25 March 2014

**Re: Proposed Section 96 (1A) Modification to SSD 5307_2012 and SSD 5729_2012
Bega Valley Health Services Redevelopment**

Overall Elevations
DRAWING NUMBER: **BW-ARC-C1-XX02** ISSUE: **4**

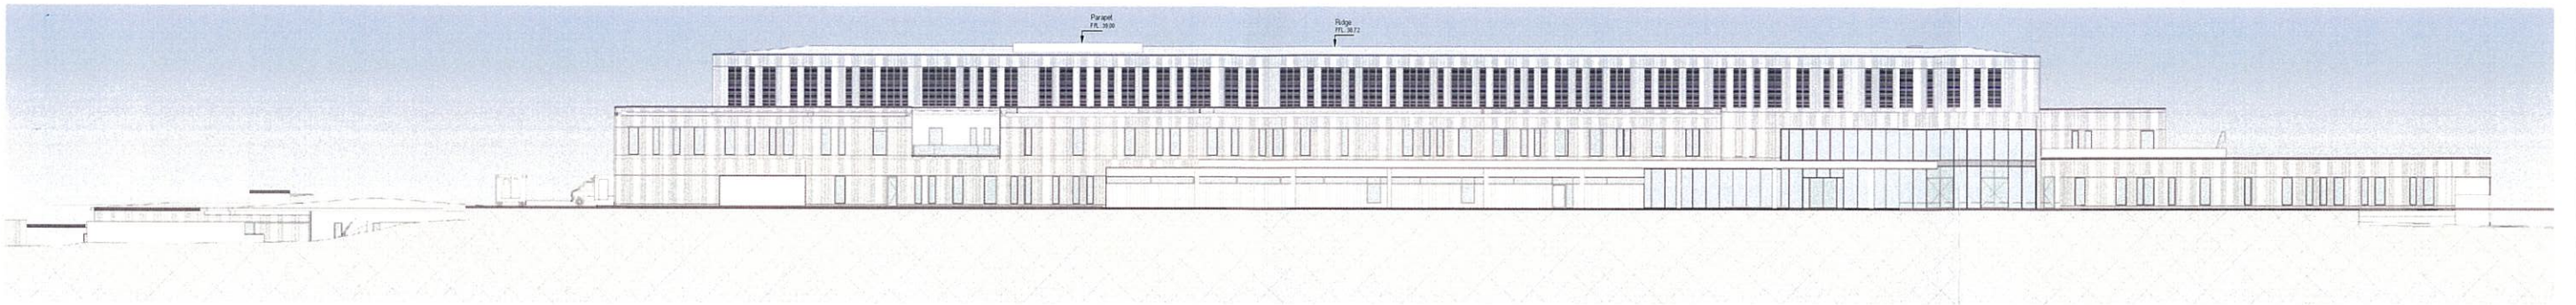
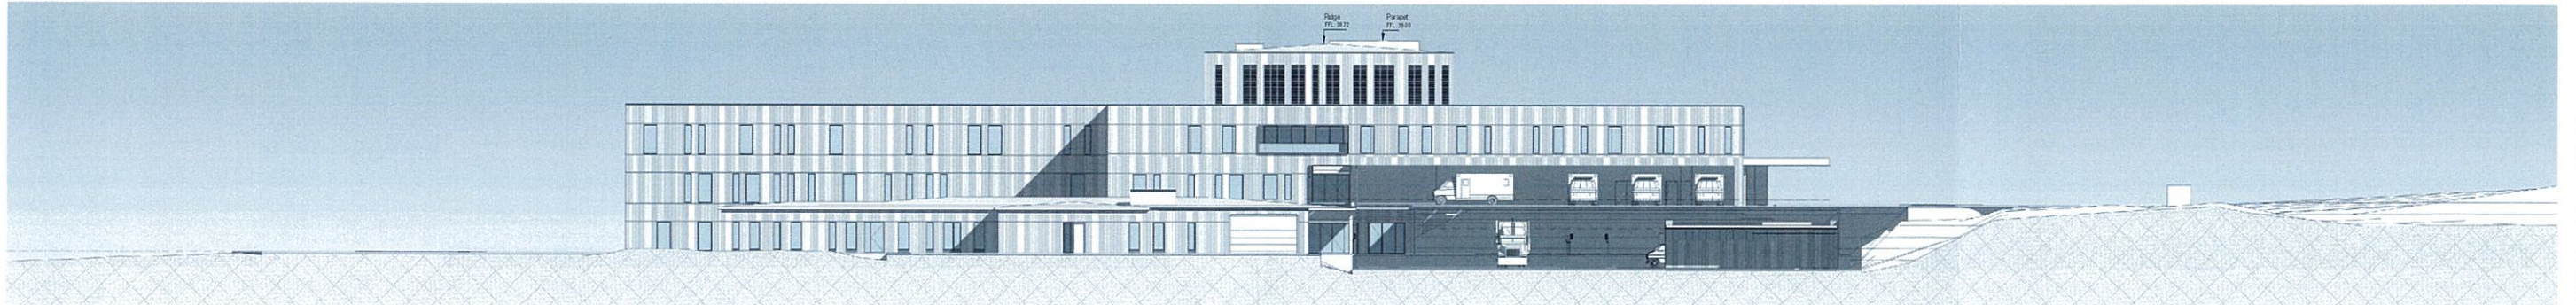
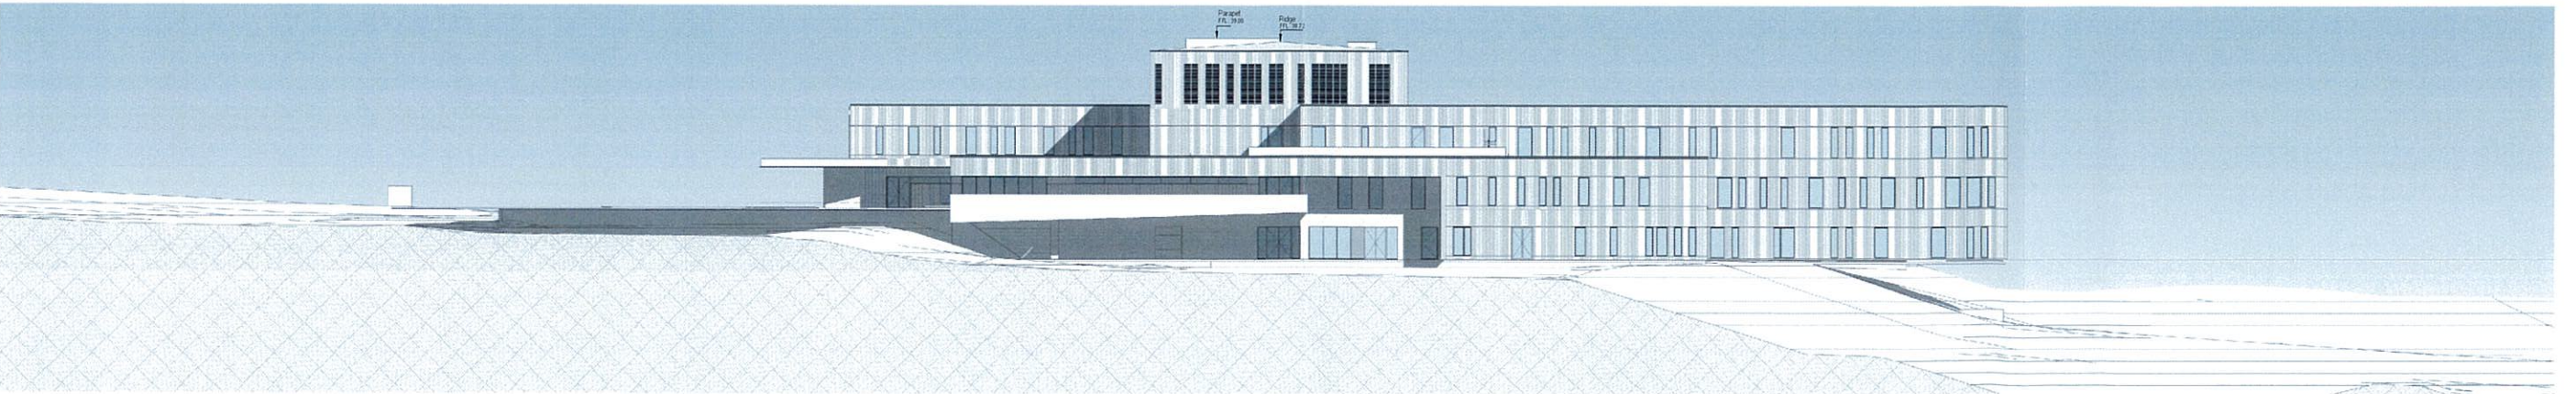
The approved design includes a pitched roof constructed of metal sheeting in specific locations. The revised design replaces the pitched roof with a flat style roof. In addition the height of the building is increased by 200mm from RL 38.80 at the ridgeline to RL39.00 to allow for greater floor to ceiling heights. The amendment will have no impact on the external environment and is considered to be a very minor change (refer to Attachment A).

<i>Issue</i>	<i>Action</i>
Condition A2	Amend date of Drawing PA-0X08 dated 9/7/2013 to BVN-ARC-C1-XX02 Issue 4 dated 4/2/14 as per the attached revised drawing.
Condition B1 a)	Amend "The maximum height of the building is RL39.00AHD"

1
SK_108
1 : 500
PLANNING ELEVATION EAST

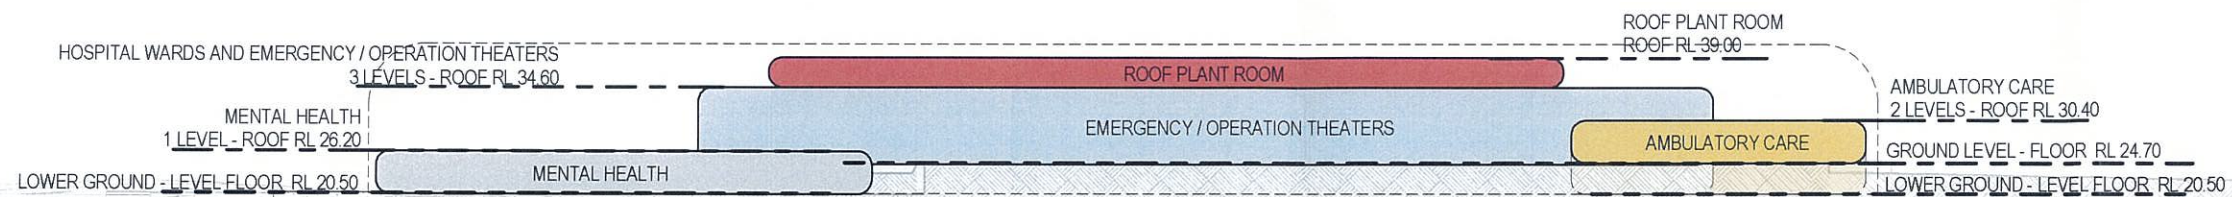
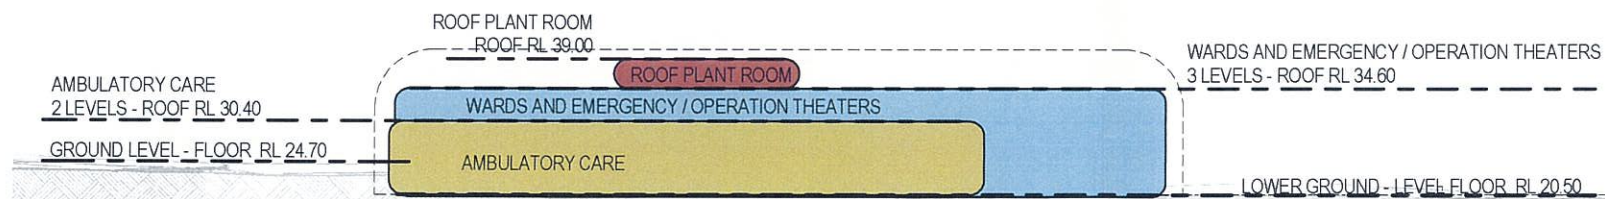
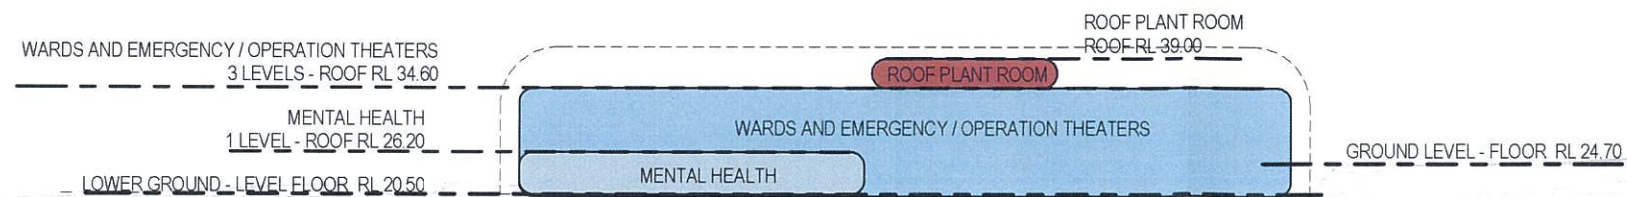
<i>Issue</i>	<i>Action</i>
Condition A4	Amend date of Drawing SK_107 and SK_08 dated 8.10.12 to SK_107 and SK_108 dated 18.3.14 as per the attached revised drawing.
Condition A8.	Delete
Condition A17	Delete
